From: Contact Centre (CRM) <contact@ribblevalley.gov.uk>
Sent: 07 December 2025 15:39
To: Planning
Subject: Planning Application Comments - 3/2025/0564 FS-Case-771663645

Planning Application Reference No.: 3/2025/0564

Address of Development: The Old Wheatsheaf Pub, 45-47 Whalley Road, Clitheroe, BB7 1EE

PL01

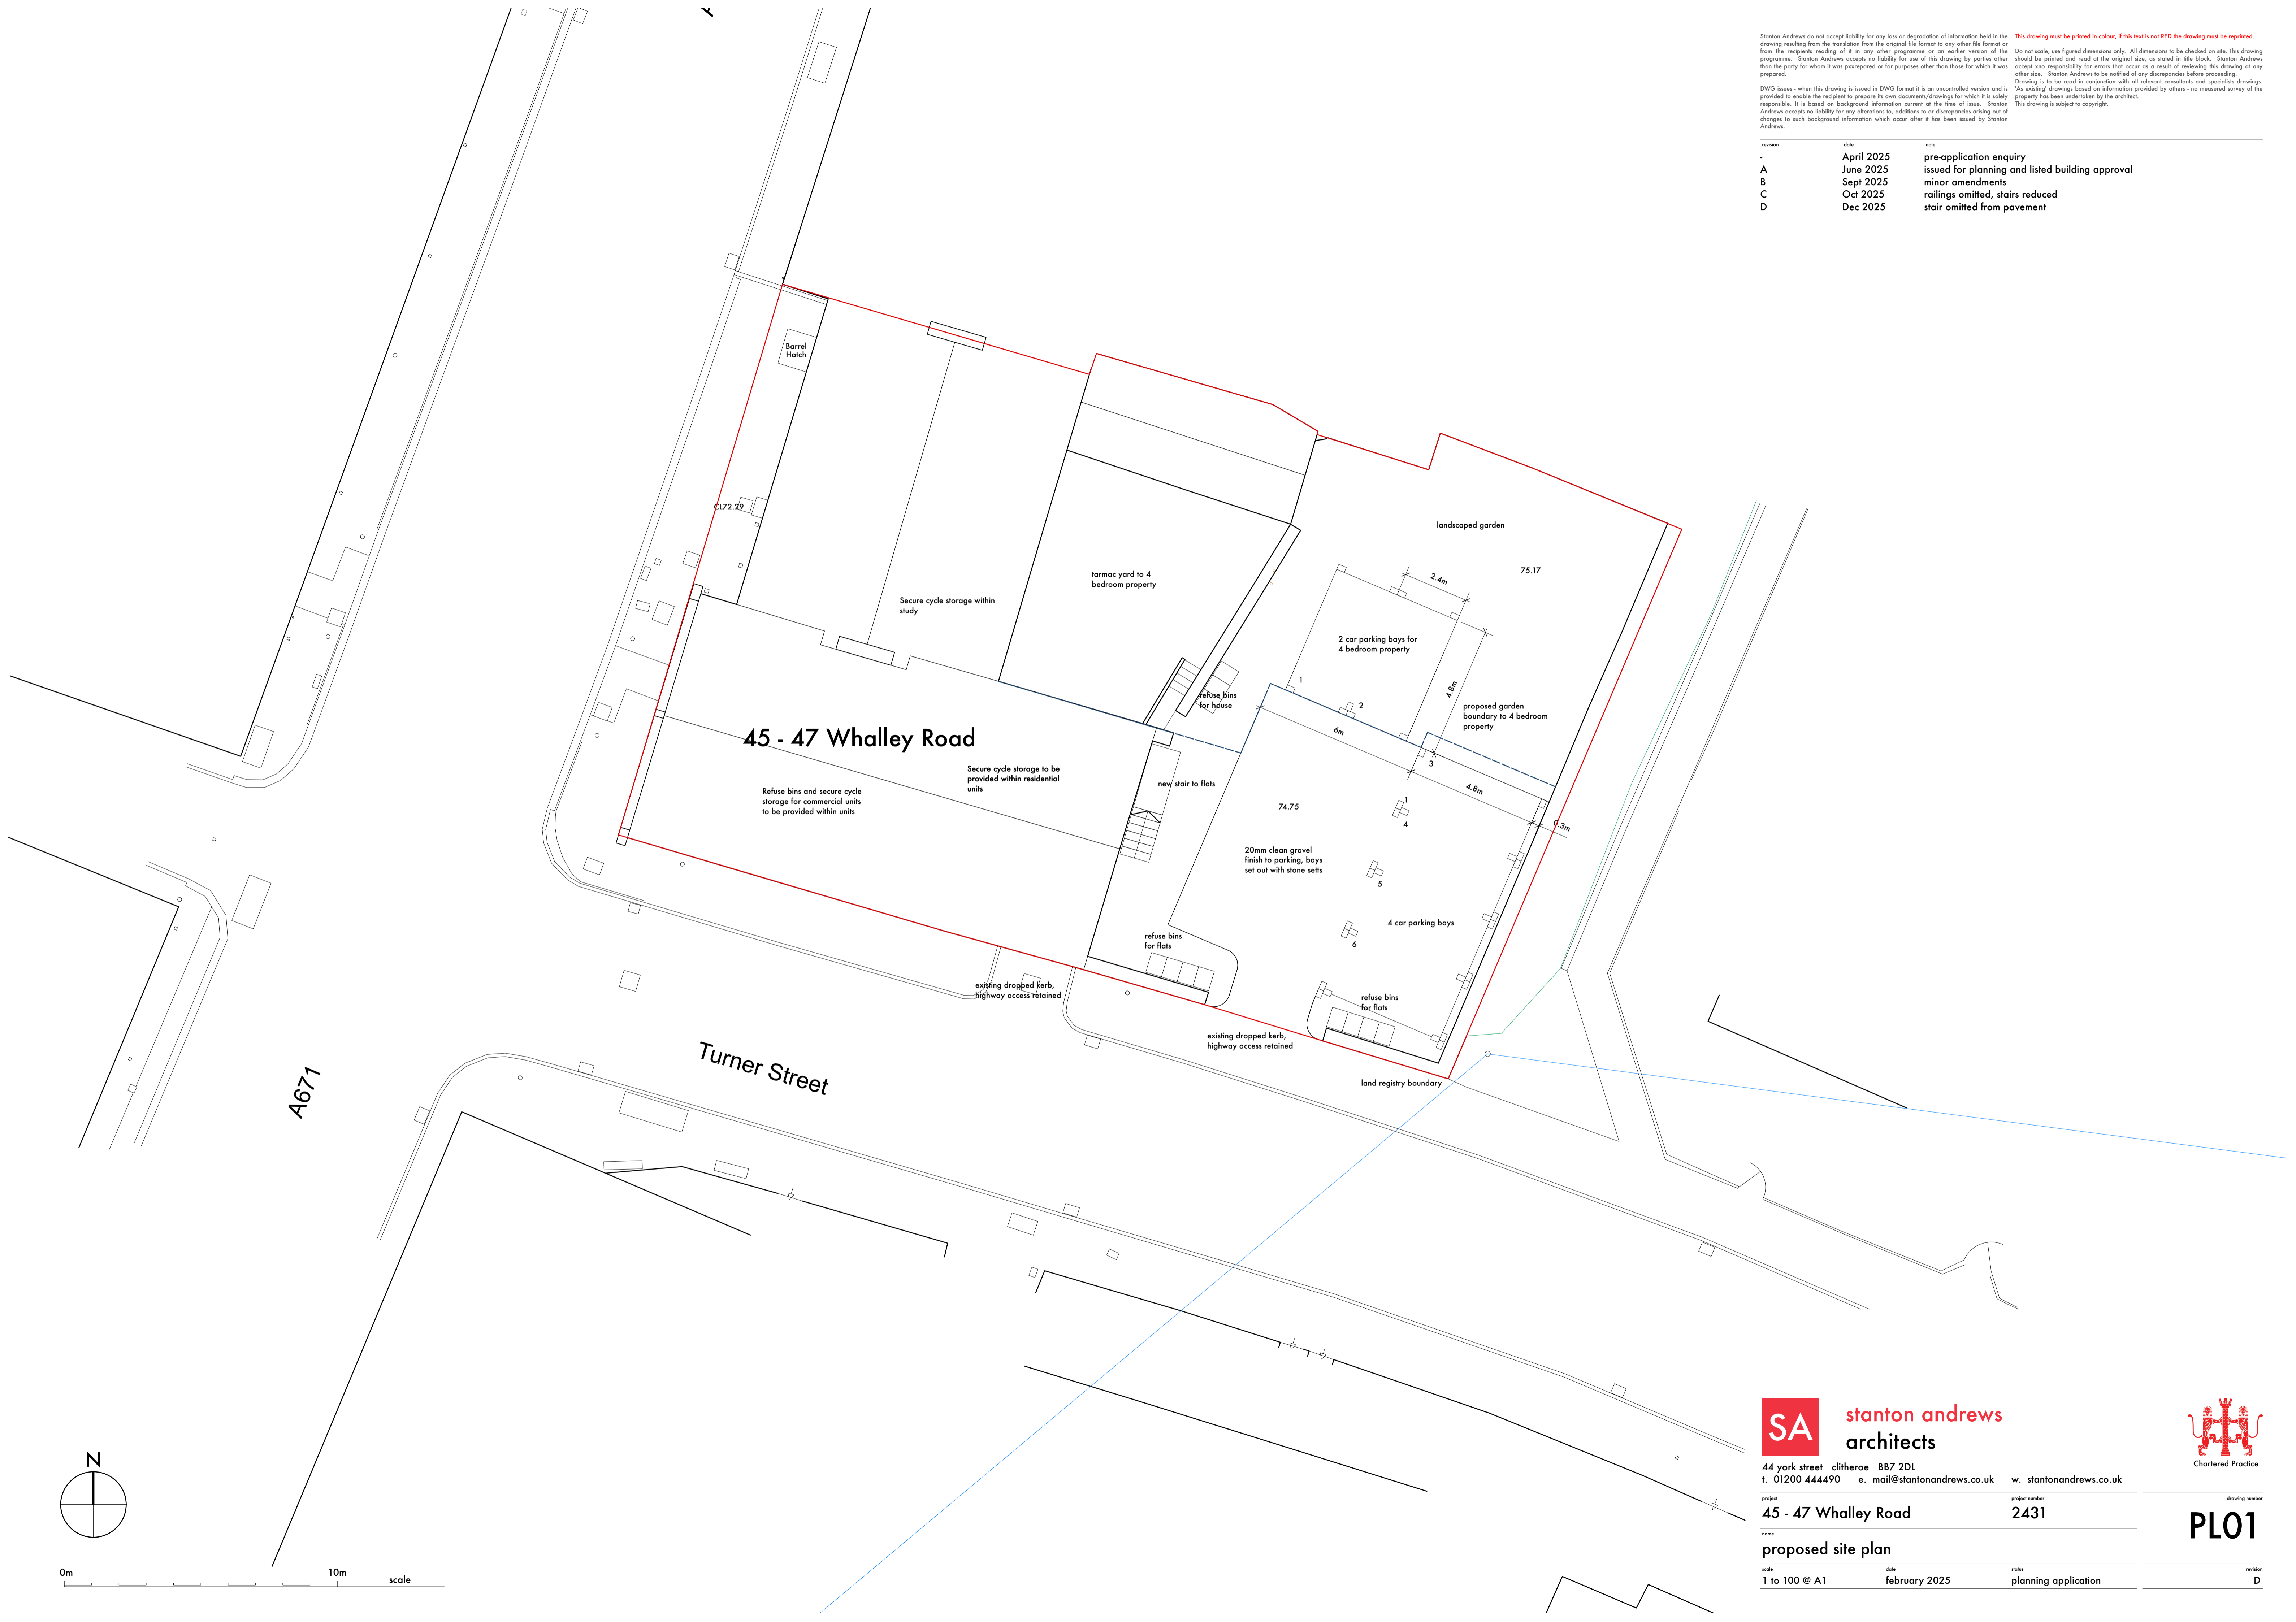
We are also concerned about the impact of increased competition for parking on-street as the on-site off street parking set out in the plans seems to be radically lacking when compared with the number of houses and commercial units the application seeks to establish.
